DECISION NOTICE

Our Ref: 23/00138/FUL
Your Ref: Alterations and
Reordering - ...

Location:	Paradise Lodge, Weston Under Redcastle, Shrewsbury, Shropshire
Proposed Development:	External alterations to the existing dwelling and the formation of a new external bridged walkway. Repairs of external ground finishes and repointing of masonry
Application No.	23/00138/FUL
Date Received:	13th January 2023
Applicant:	Sir Algernon Heber-Percy

Notes

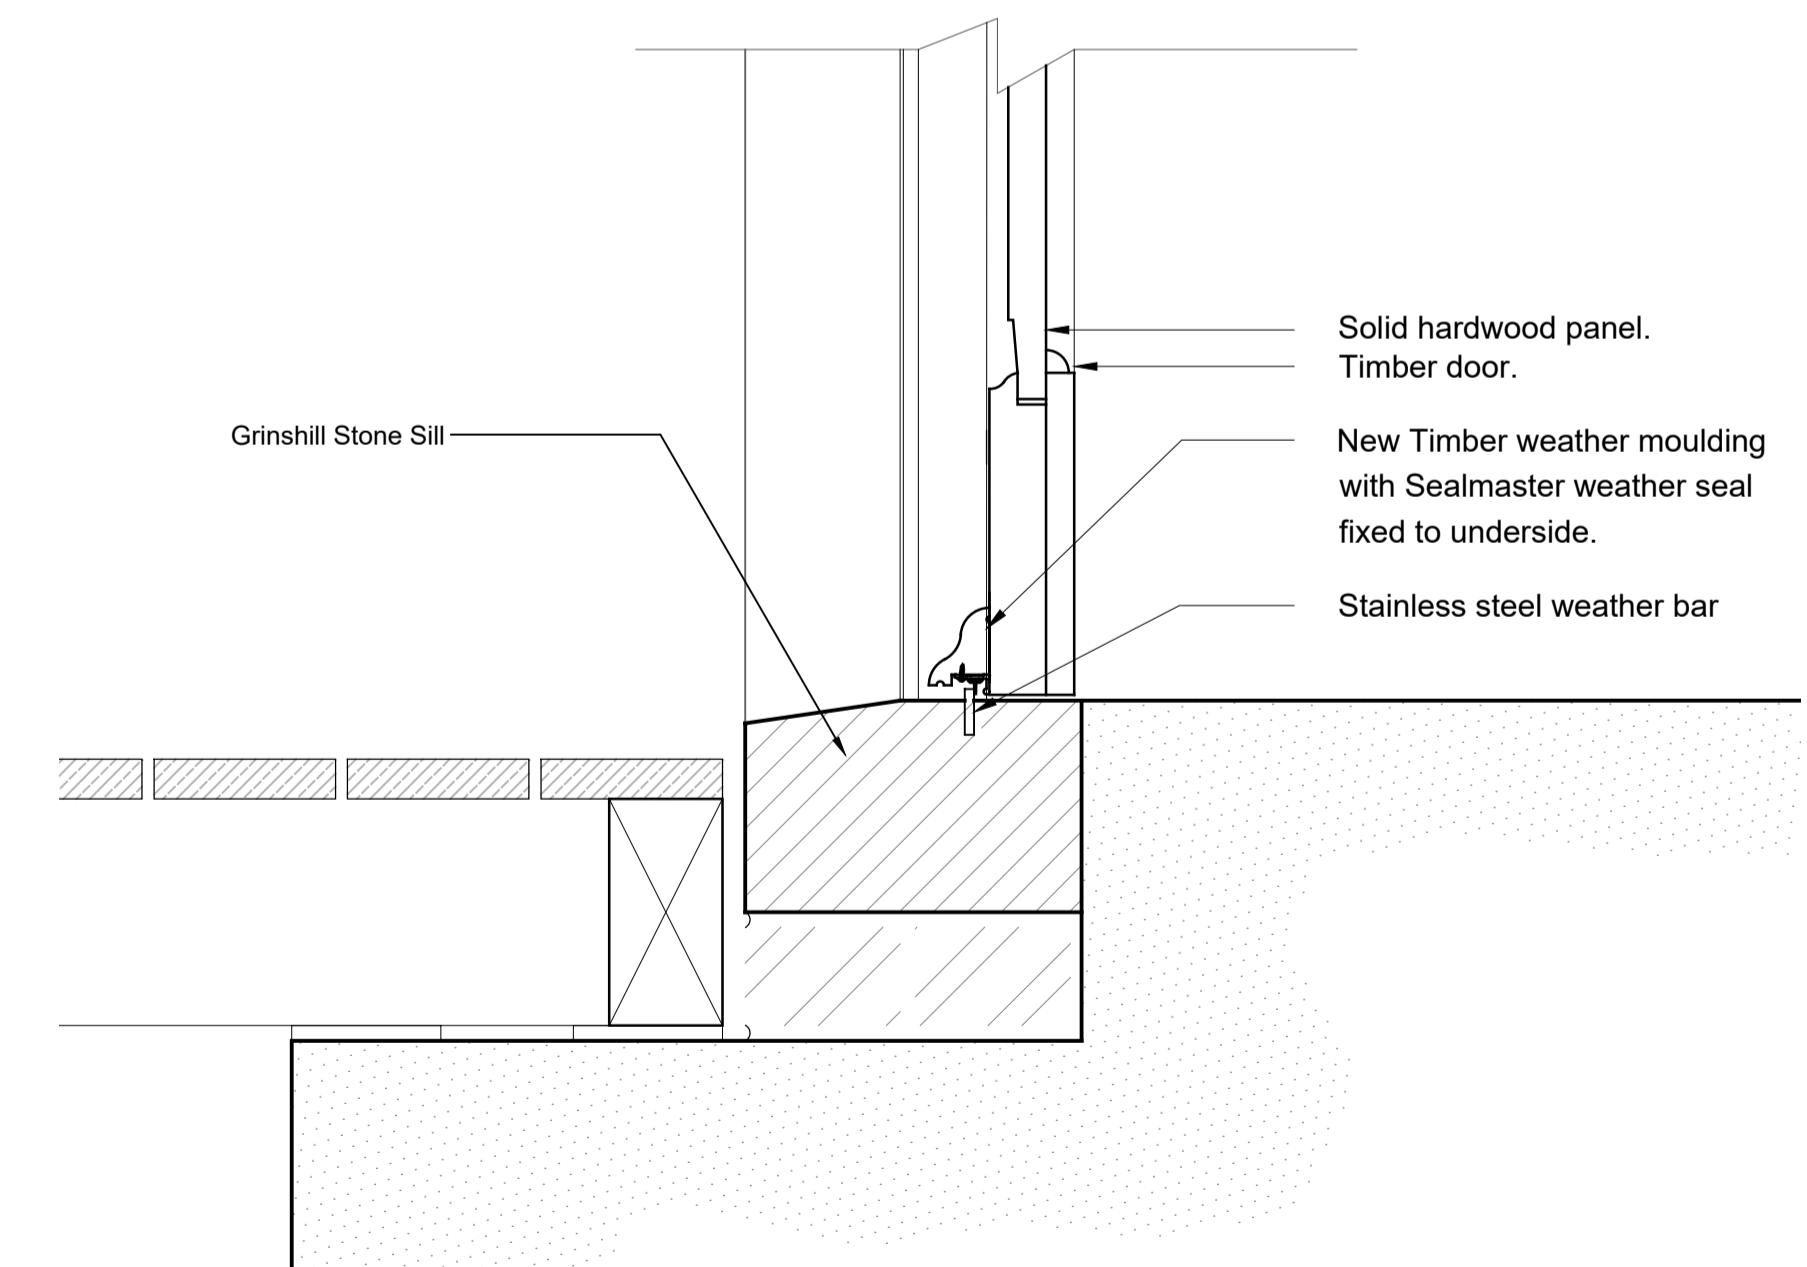
8. Notwithstanding the detail shown on drawing numbers 3201 and 3202, details of all external windows and doors and any other external joinery shall be submitted to and approved in writing by the Local Planning Authority prior to the commencement of the relevant work. These shall include full size details, 1:20 sections and 1:20 elevations of each joinery item which shall then be indexed on elevations on the approved drawings. All doors and windows shall be carried out in complete accordance with the agreed details
